# City of Albuquerque Stormwater Construction Site Inspection Report

ESC File No.	K09E051	Project Name:	Titan (Spec) 150K		
NPDES Id. No.	NMR1004R6	Location:	Daytona and Bluewater Rd		
7/12/2023	Owner	Contractor			
Operator	Westpoint 40, LLC	Wilger Construction			
Contact name & title	Brian Patterson	Tim Lindgren			
e-mail	<a href="mailto:bpatterson@titan-development.com">bpatterson@titan-development.com</a>	<a href="mailto:tlindgren@wilger.com">tlindgren@wilger.com</a>			
Contact Phone #	505-998-0163	505-239-0246			
COA Inspector	Chancellor English	Start/End Time:	10am		
Construction Phase:	Paving, landscaping, interior				
Type of Inspection:	Regular	Storm Event	Post Storm Event >0.25"	311/Complaint	Follow Up
Weather at time of inspection?	Clear		Temperature: ~	95	
Estimated date of last storm 0.25" or greater	5/22/2023

SEDIMENTATION/SILT FENCE WITH WIRE SUPPORT (SF)

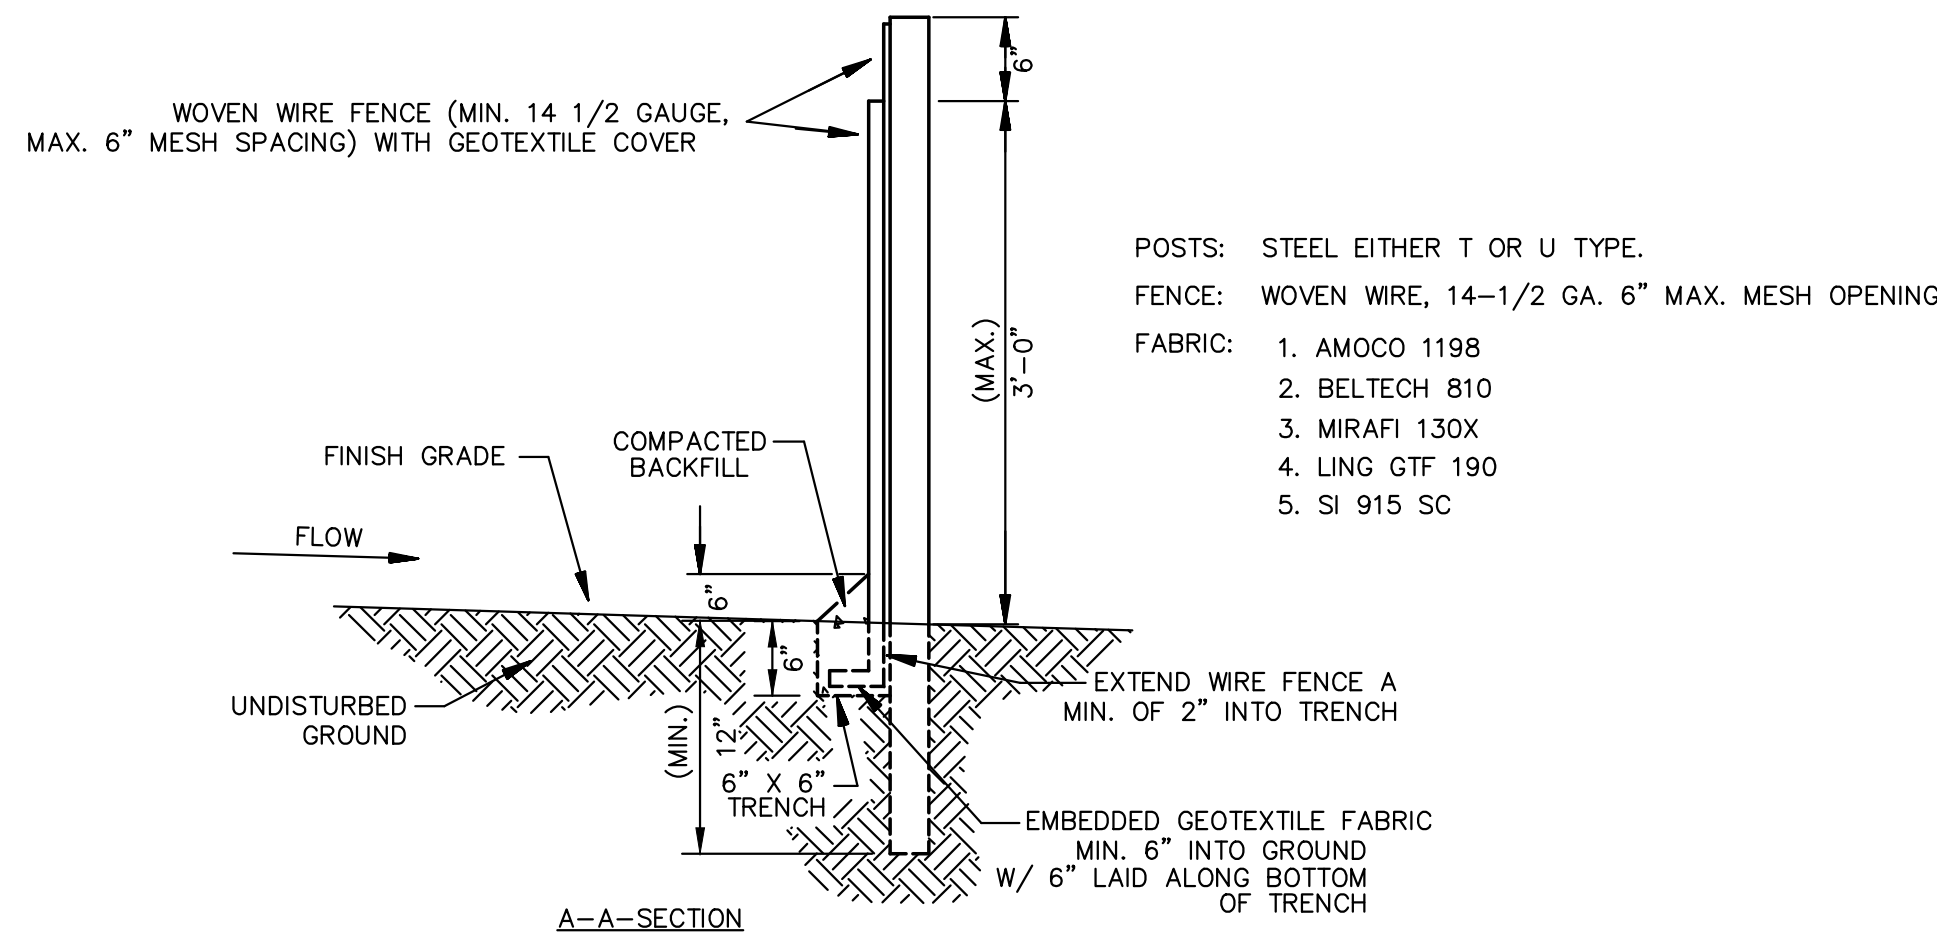
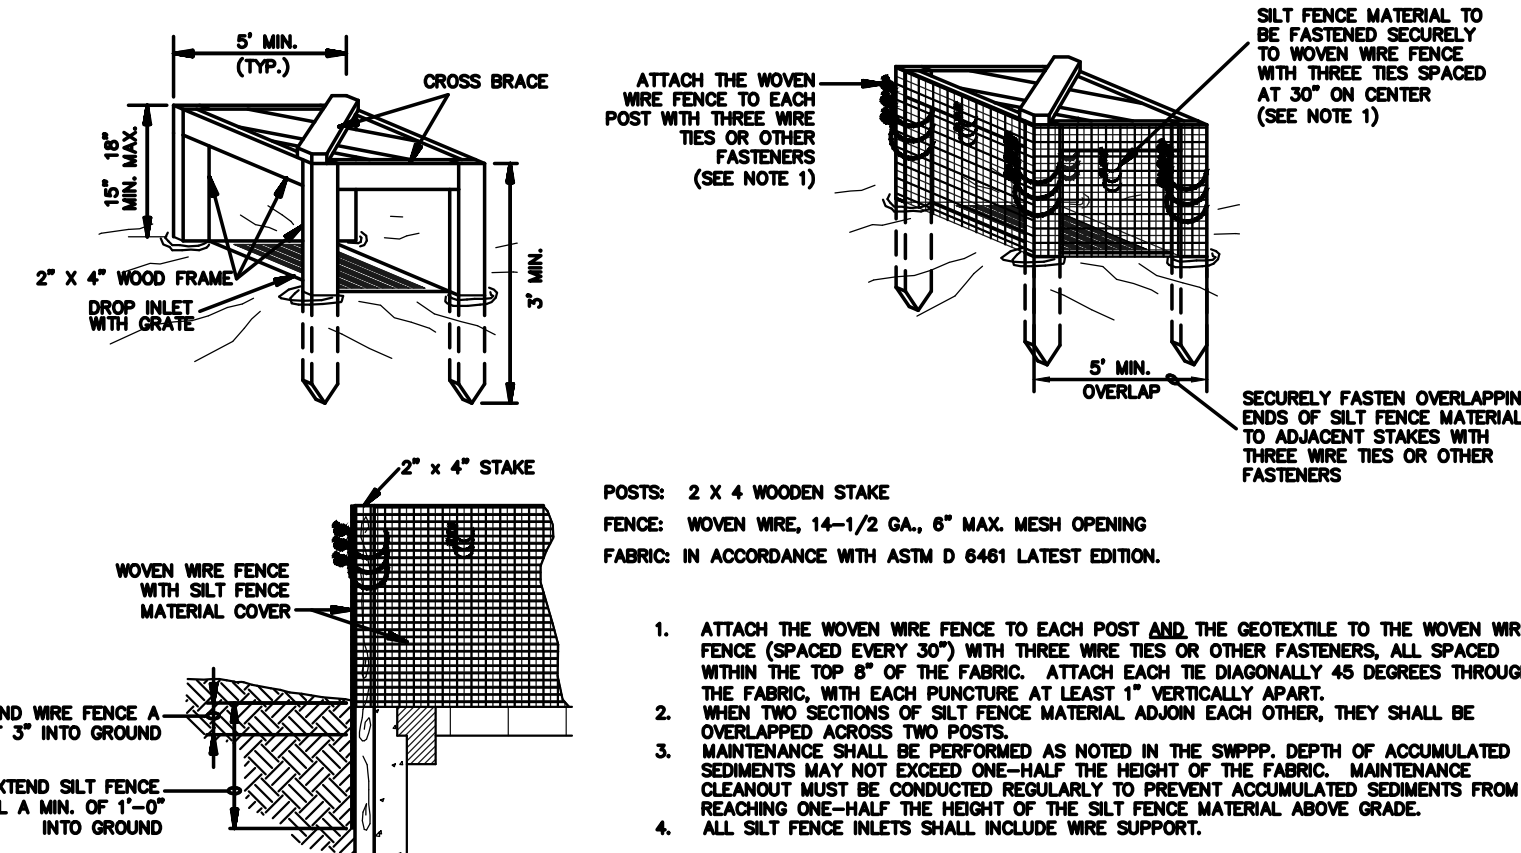
2	BMPs were damaged or collapsed. Multiple sections of the perimeter silt fence on the west and south edges of the properties need maintenance and/or repair. Required mitigation: You must ensure all stormwater controls are maintained and remain in effective operating condition during permit coverage and are protected from activities that would reduce their effectiveness per CGP 2.1.4.			
3	There is sediment discharge originating at a dirt ramp that has been recently installed on the southwestern corner of the Aspen and Autumn, LLC property that exits onto Bluewater Road. The track-out has caused a significant sediment trail along the curb of said road. Required mitigation: You must restrict vehicle use to properly designated exit points, use appropriate stabilization techniques at all points that exit onto paved roads, implement additional track-out controls to ensure that sediment removal occurs prior to vehicle exit, and remove, by proper measures, the deposited sediment by the end of the same business day, or next business day if occurring during on a non-business day per CGP 2.2.4.
